Application no: H09/0372/02

Description: Erection of 7 dwellings (5 bungalows, 2 houses)
including demolition of existing bungalow and
outbuildings

Location: Rear of 32 Fishpond Lane
Holbeach

Amendment: Widening of private drive
Dwg.no. SD01-061/1

SD01-061/1

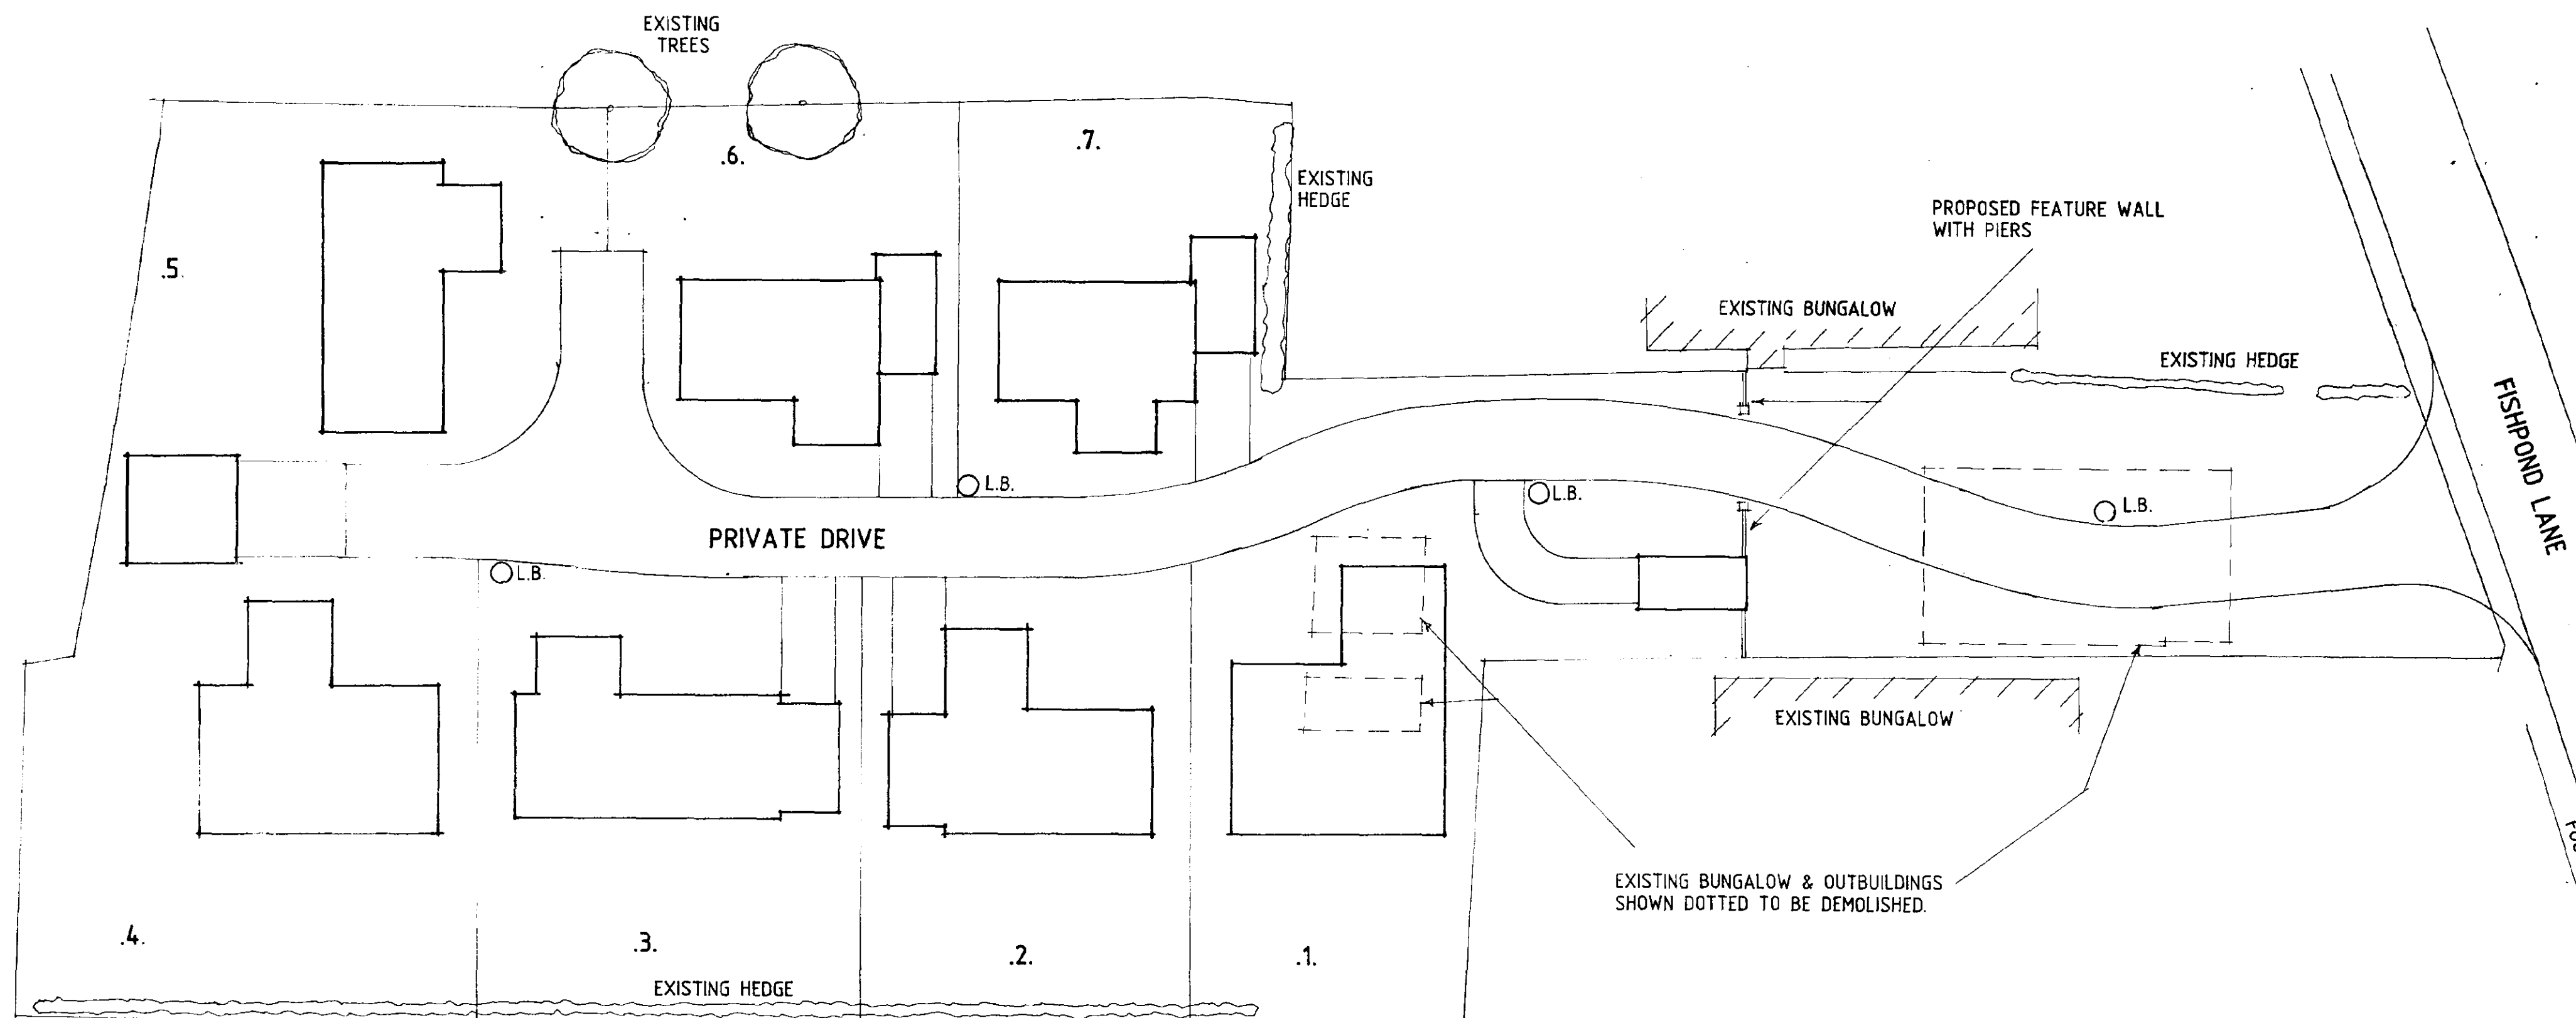
WIDENING OF PRIVATE DRIVE
